31 July 2018

Our Ref: HW2018-3

SUBMISSION RE: ENVIRONMENTAL IMPACT STATEMENT FOR CATHERINE MCAULEY CATHOLIC COLLEGE – 2 KINGFISHER CLOSE, MEDOWIE – SSD 8989

Water Quality (MUSIC) Model

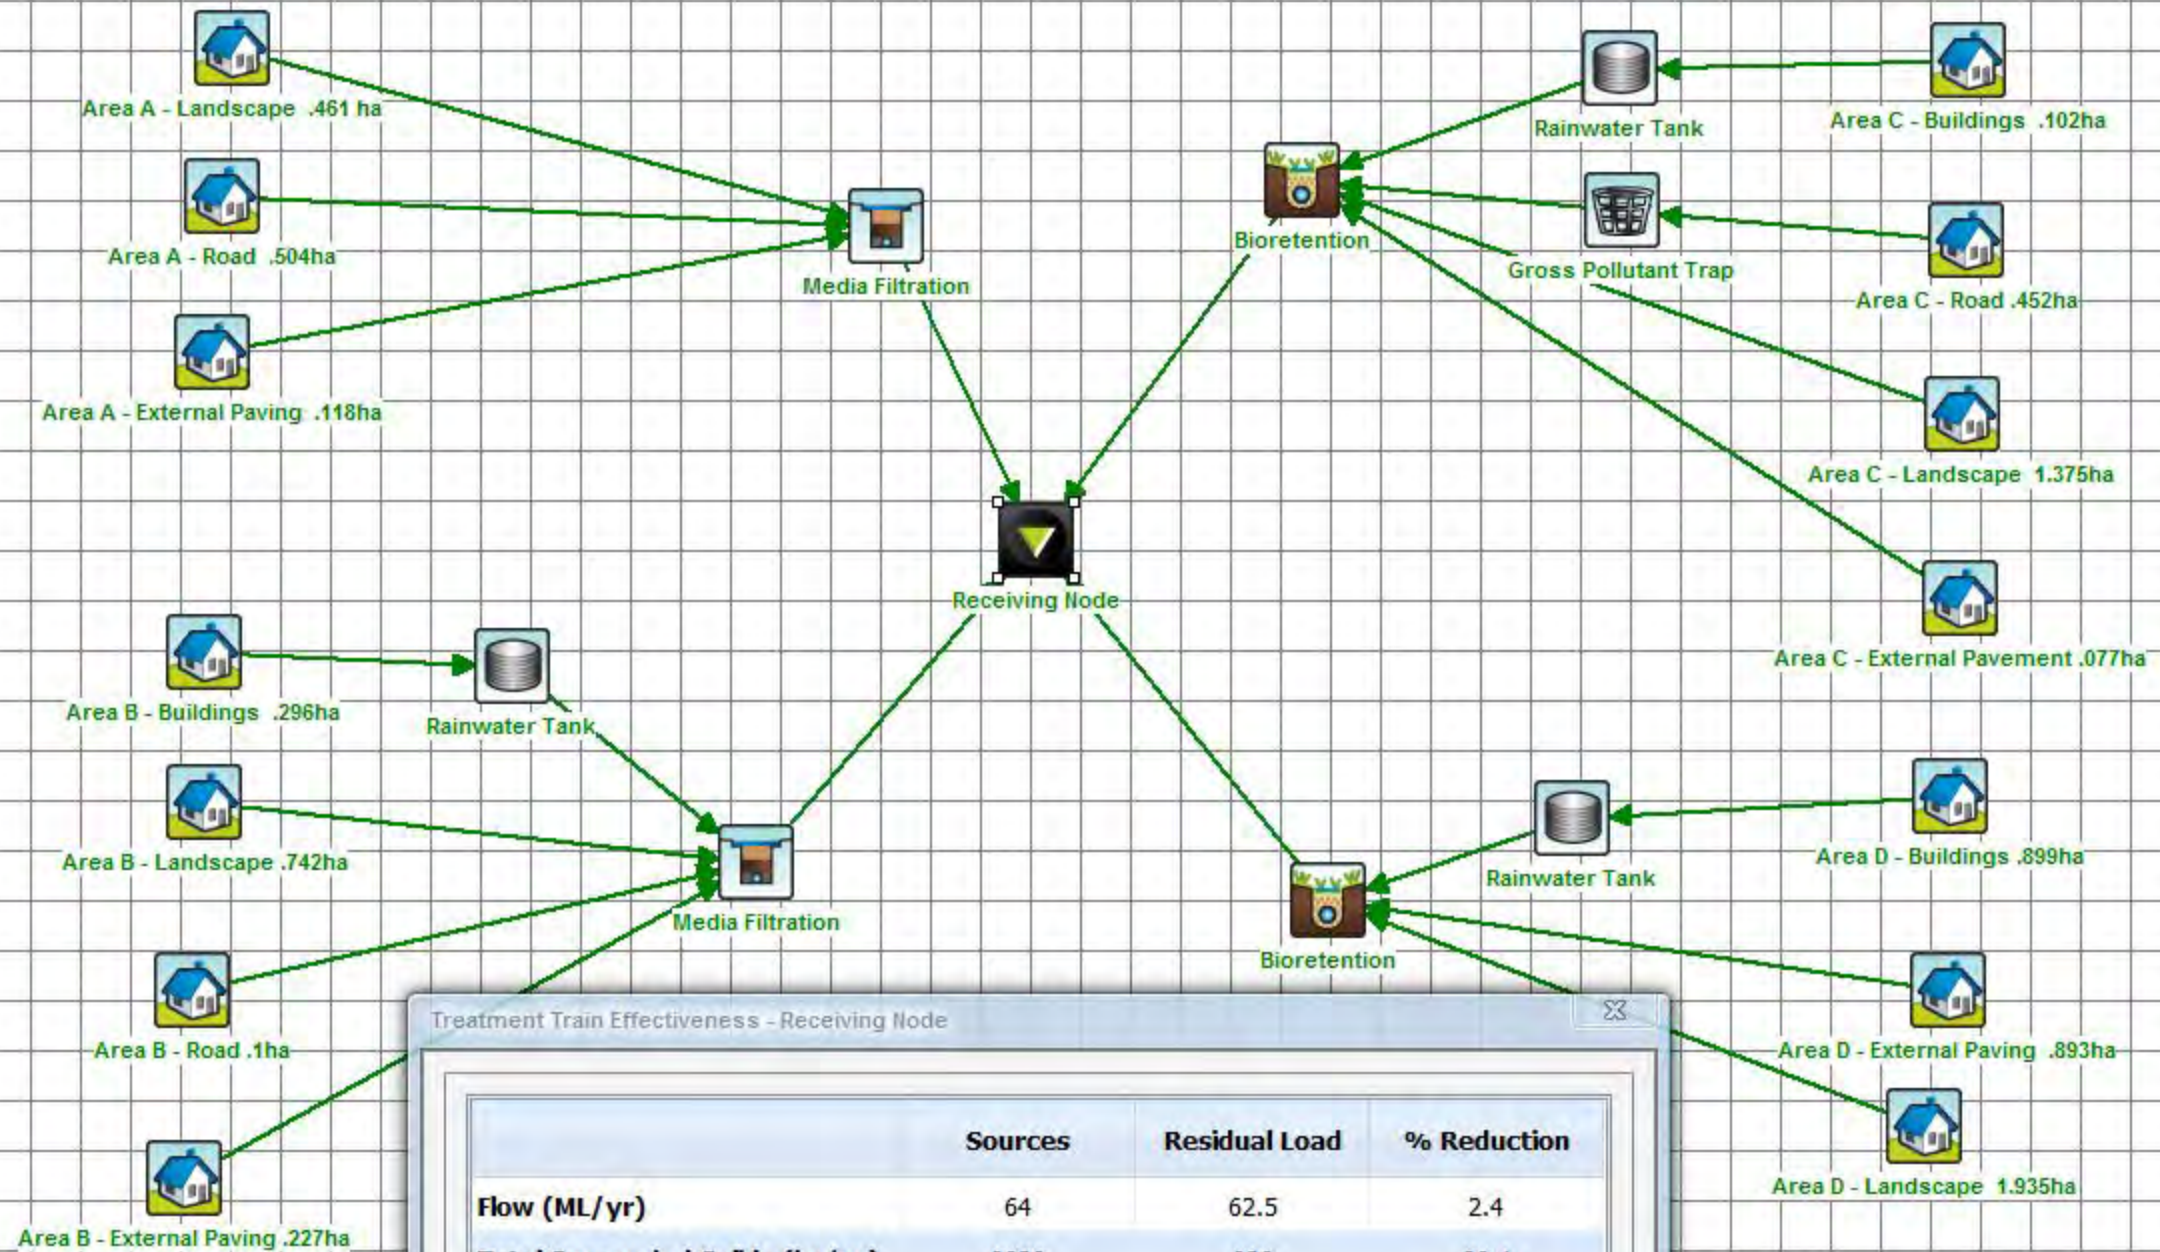
- *Detail measures to minimise operational water quality impacts on surface waters and groundwater. The development must demonstrate Neutral or Beneficial Effect on Water Quality (NorBE) in terms of stormwater runoff using Model for Urban Stormwater Improvement Conceptualisation (MUSIC) modelling using the appropriate Port Stephens Council MUSIC Link catchment and default parameters.*
- *A comparison between existing and expected post-development pollutant loads in stormwater runoff should be made to demonstrate that the proposed stormwater infrastructure and treatment train will satisfactorily address water quality concerns for the typical stormwater pollutants of total nitrogen, total phosphorus, total suspended solids and gross pollutants.*

The Stormwater Management Plan (Appendix 15 to the EIS) only assessed treatment train effectiveness and did not address NorBE. In fact, the stormwater management approach described in Section 3 of the Plan and the proposed water quality facilities in Section 4.7 of the Plan refers to the Port Stephens Council DCP but make no mention of NorBE. As such, Hunter Water has not been able to undertake a detailed assessment of the MUSIC modelling at this point. Hunter Water's estimates of the pre-development loads from the site suggest that the proposed treatment train may fail to meet NorBE for both total phosphorus and total nitrogen. The Proponent must undertake the required modelling to demonstrate how the development can meet NorBE prior to determination of the application. The modelling files and the MUSIC Link Report should be provided to Council and Hunter Water for review, at which time a detailed assessment of the model inputs and outputs will be undertaken.
